**Our Ref: FP/166/13/
Your Ref:**

Application for Planning Permission for Works or Extension to a Dwelling

Development Front extension comprising of porch with wc

Location 44 Andrew Avenue Felpham

GROUND FLOOR PLAN
as proposed

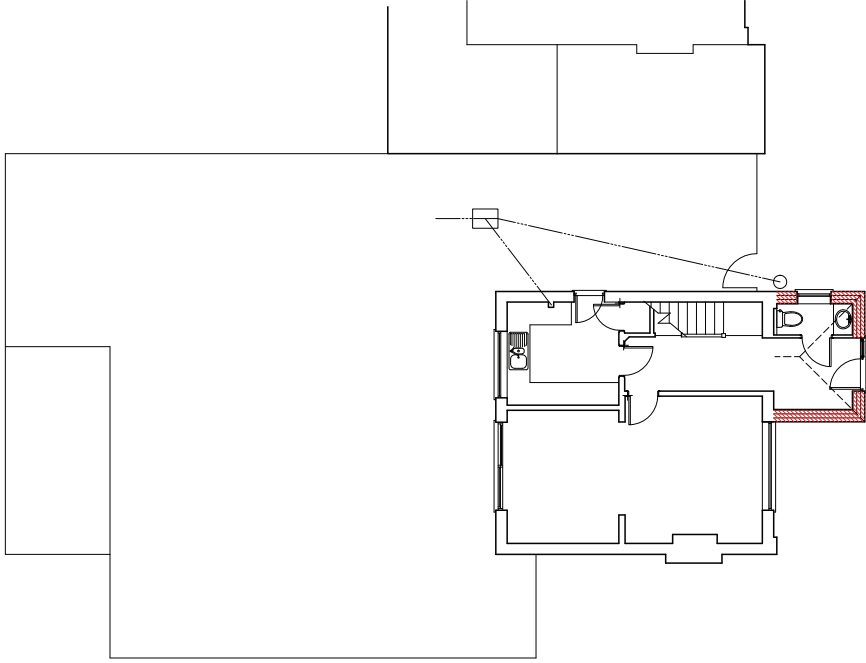
The drawing with the proposed plans on has the 'proposed' floor plan headed as 'existing'. Please forward amended plans accordingly.

1/500 scale Plan

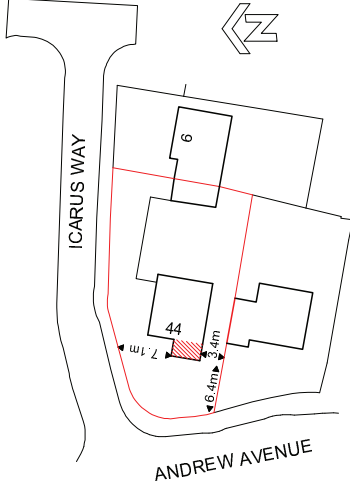
All measurements from the proposal to the boundaries are required. Please send a revised block showing the measurement to the North boundary line.
